Subject: Fwd: Application Ref: LU/164/19/PL - 5 Arundel Road, Littlehampton

Environmental Health: I acknowledge information already provided in the Planning Statement, dated May 2019, Ref 13538. I now refer to that Noise Assessment, Job Number A113884, 3rd Issue, prepared by WYG.

Studio Lack Architecture Studio Lack Ltd : 17 Beech Avenue : Chichester 01243 782 686 : nicholas.lack@live.com : PO19 3DR	5 Arundel Road, Littlehampton	Block/Site Plan 28/03/19 1/500 @ A4	Dwg 1915-03C
--	---	---	-------------------------

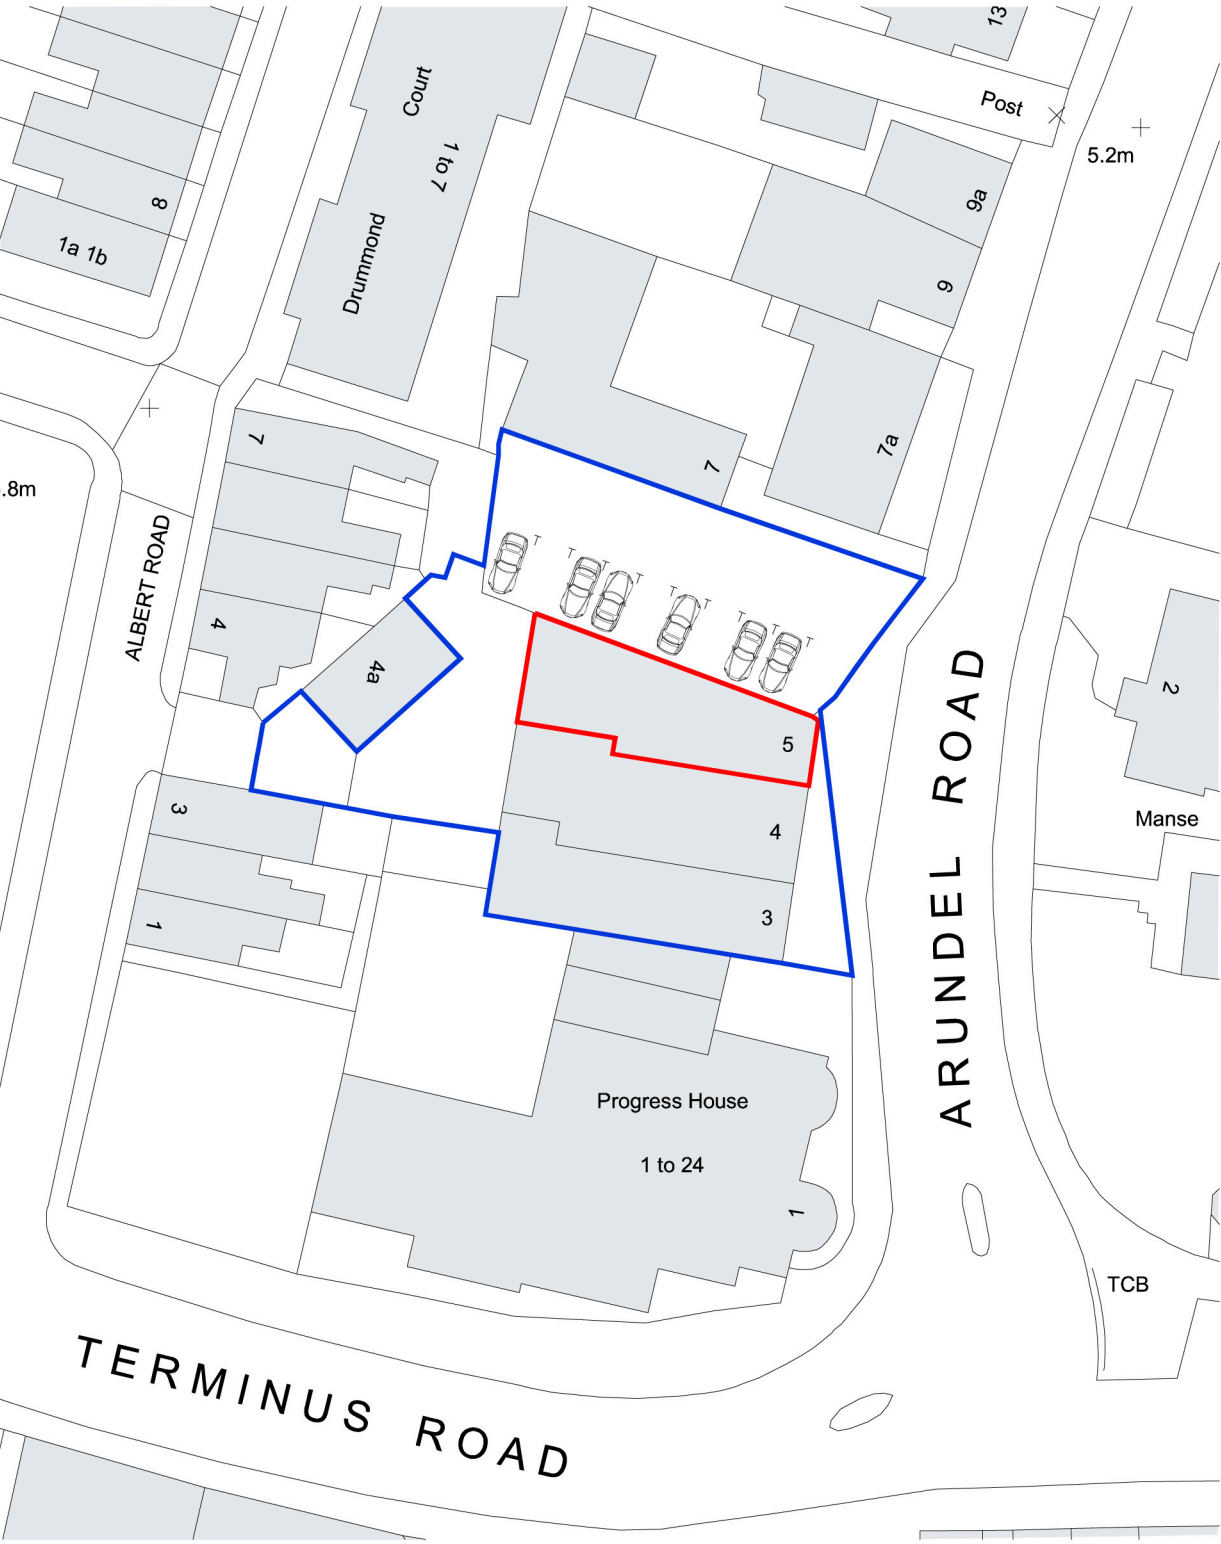
In respect of car parking, the acoustic report needs to be expanded to properly describe the acknowledged intensification of use of this space, ie the number of customer as well as the number of delivery vehicles and the type of delivery vehicles such as mopeds, etc which will arrive at/depart from this site over a given time during proposed operating hours and how this will affect the acoustic environment, particularly of sensitive receptors R5 to R10 and mitigation measures that may be necessary.

Studio Lack Architecture Studio Lack Ltd : 17 Beech Avenue : Chichester 01243 782 686 : nicholas.lack@live.com : PO19 3DR	5 Arundel Road, Littlehampton	Proposed Elevations 30/03/19 1/100 @ A3	Dwg 1915-07C
--	--	---	---------------------

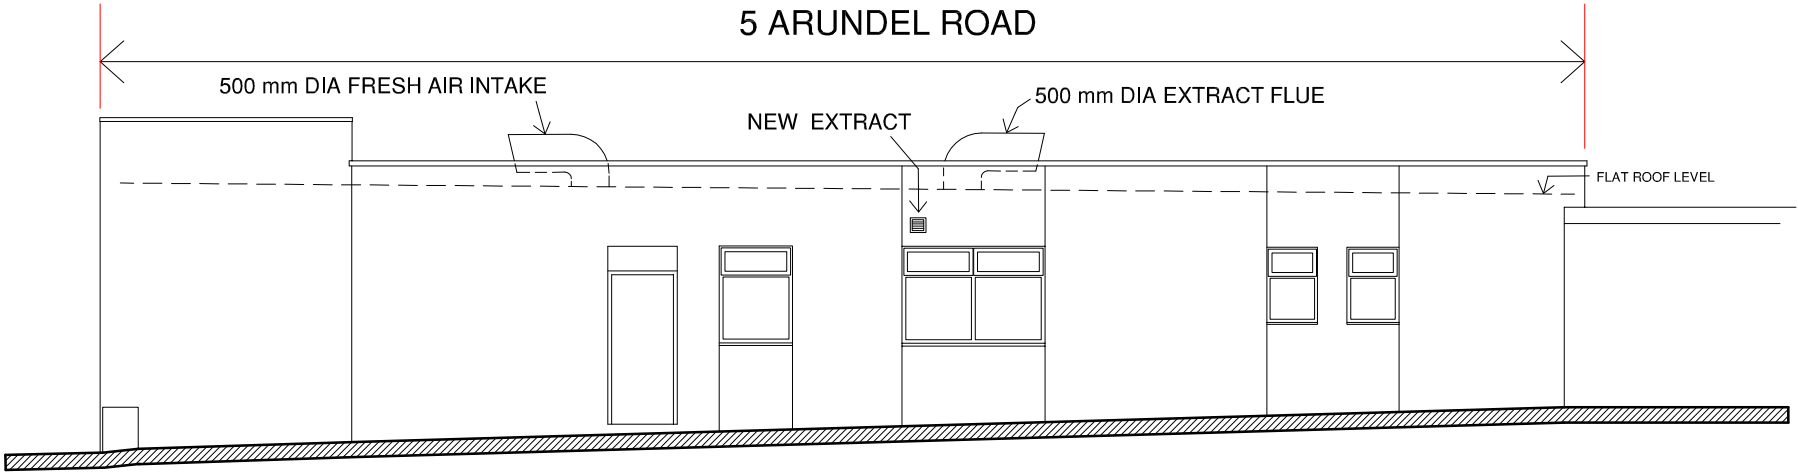
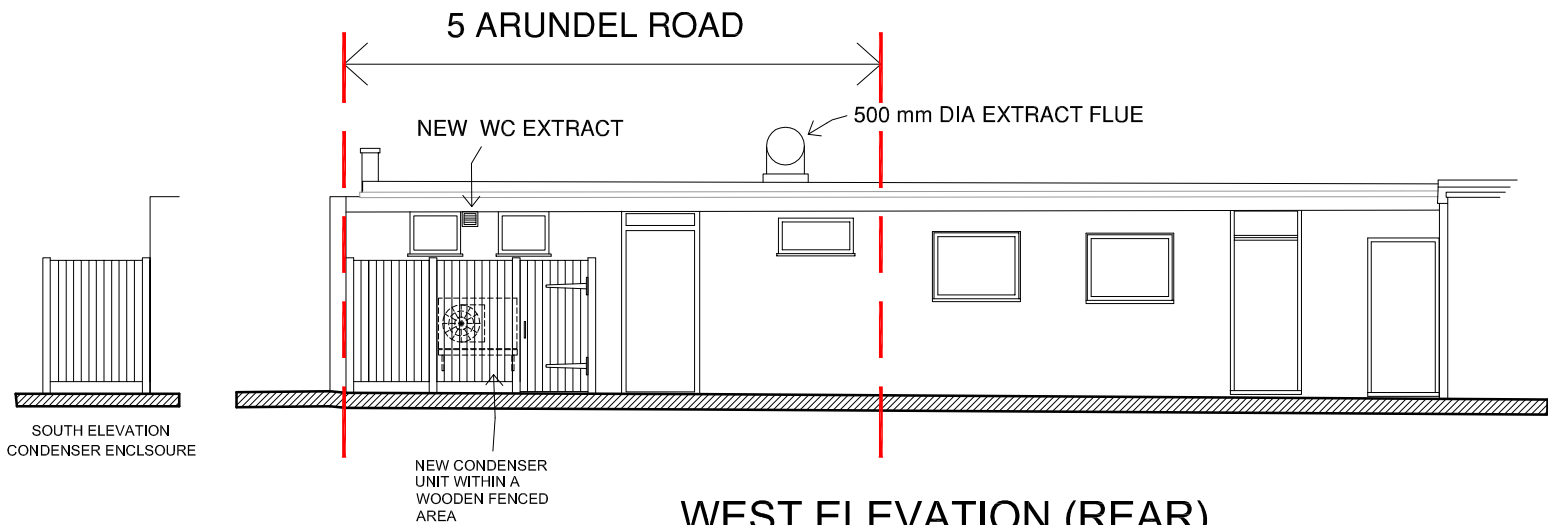
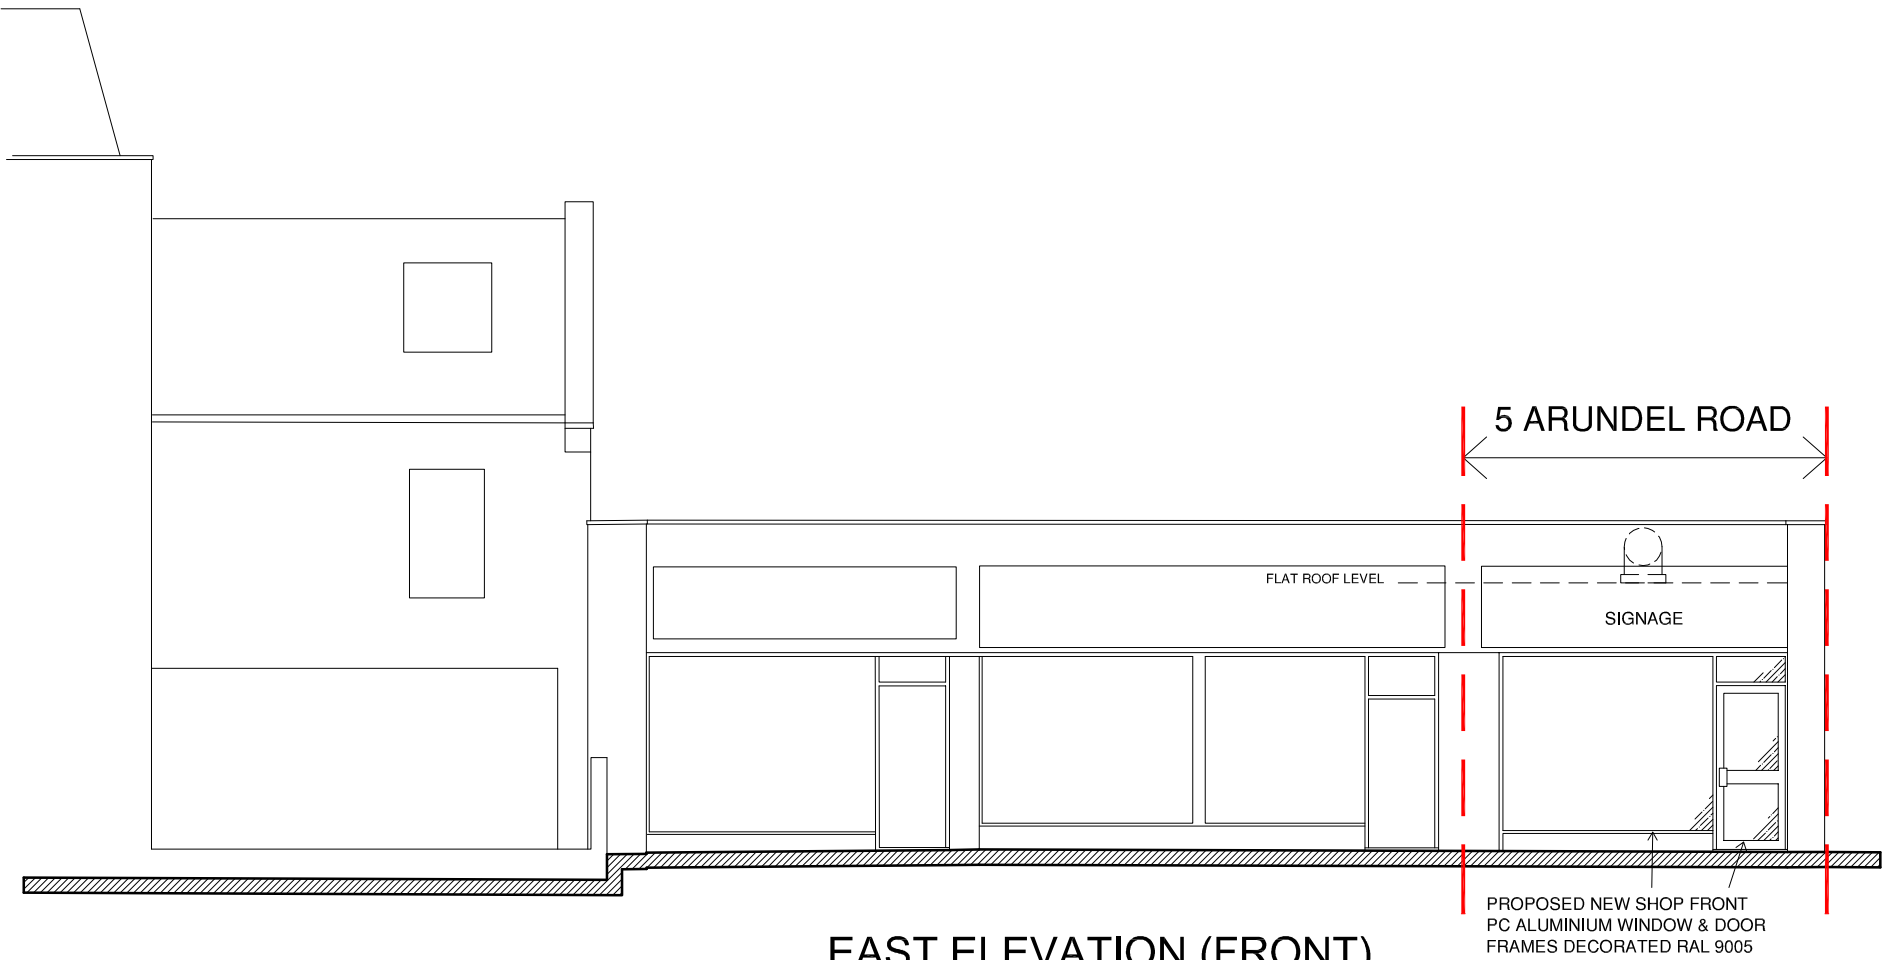
Unfortunately this report only considers noise from the condenser unit to the walk in chiller, whilst excluding other new noise sources particularly in respect of noise from the air intake and exit flue to the flat roof of this single storey building above the kitchen odour abatement system, but also extract ventilation to the kitchen sinks. Please would you request that the applicant also provides proper assessment of these areas, together with detail of any further mitigation measures that may be necessary
